Engineers Comments Regarding Condition 3 and 4

APPLICATION **LU/109/19/DOC**
NO:

Site Address: Shell Eastfield Worthing Road Littlehampton BN17 6LE

Description of Works: Approval of details reserved by condition imposed under ref LU/314/18/PL relating to Condition No 3 surface water drainage and No 4 flows to watercourses.

Typical Permavoid Geo-cellular Attenuation System with Permeable Paving and Granular sub-base Detail (Mh S12)

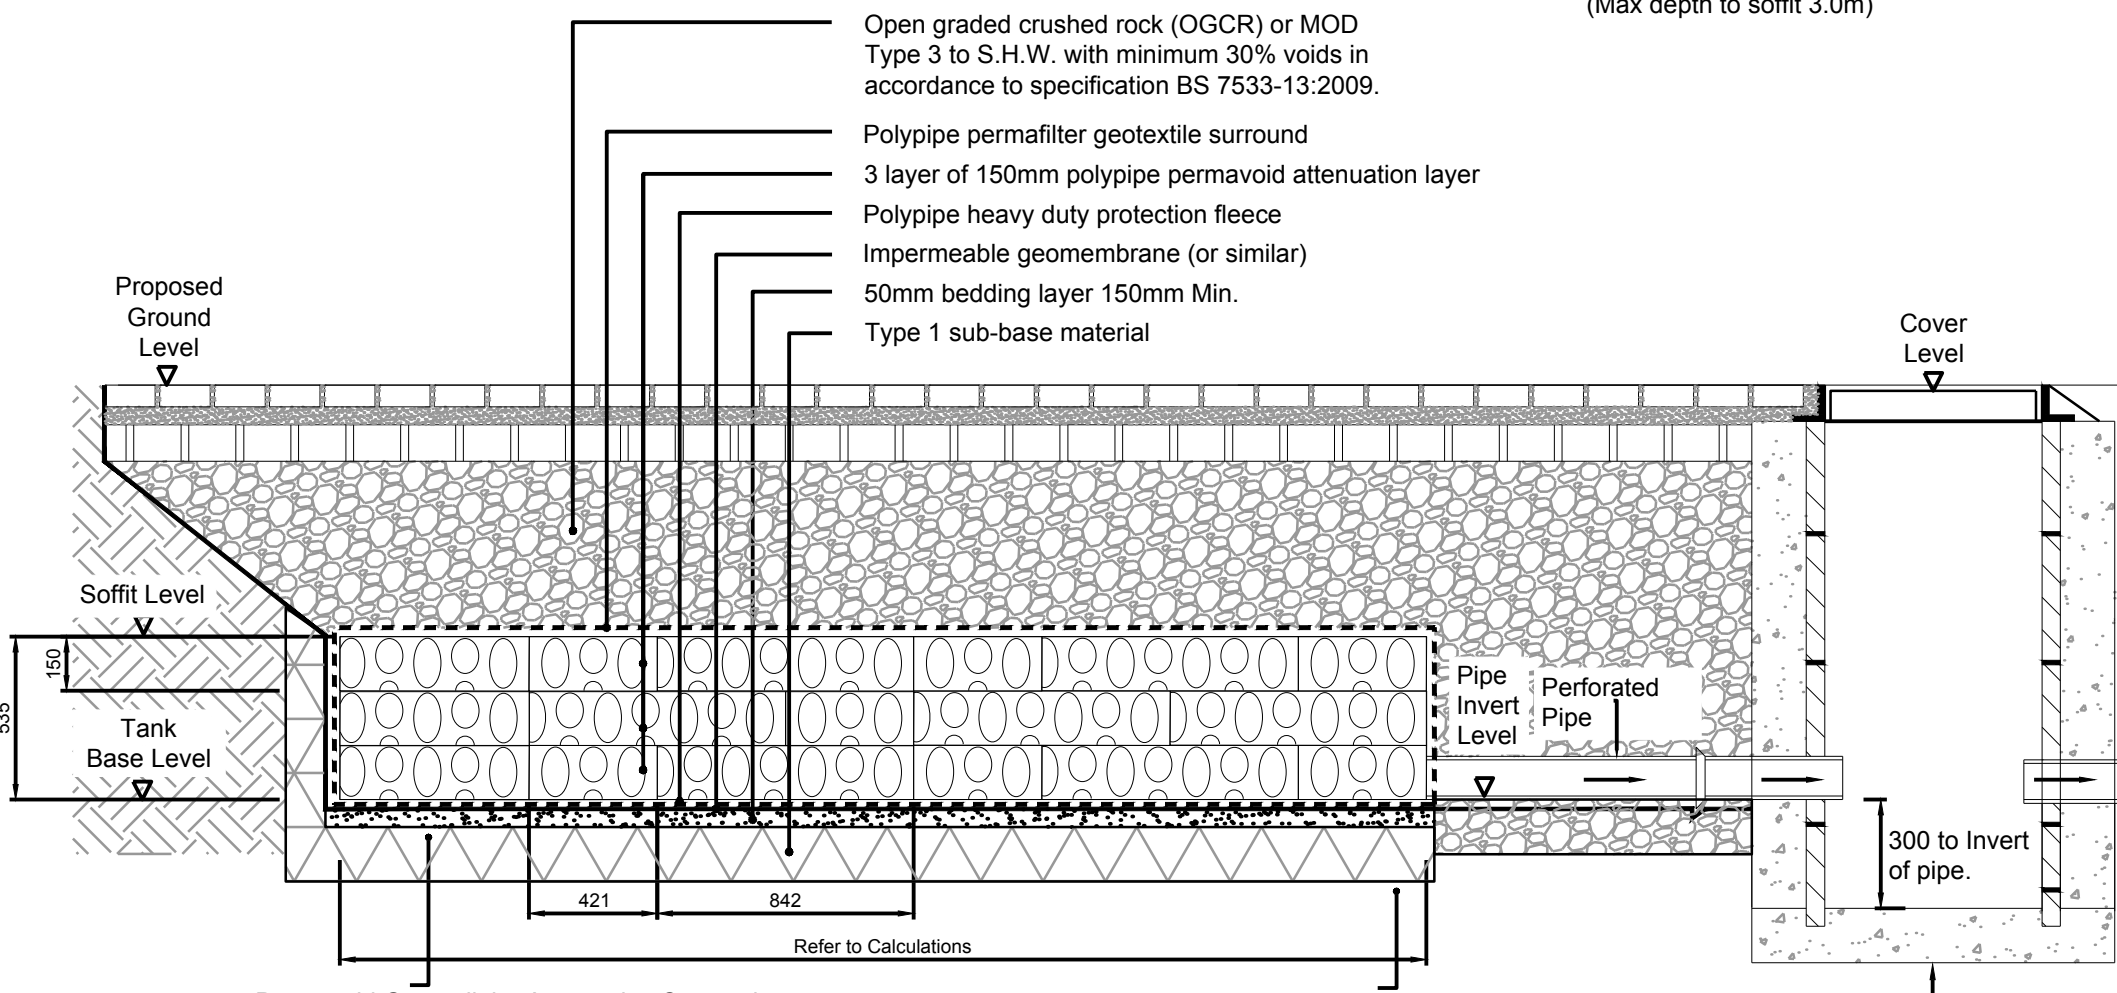
3. The layout plan provided is unclear in terms of differentiation of the two networks. Please revise line types etc.
4. Catchpit manholes should be provided upstream of attenuation tanks.
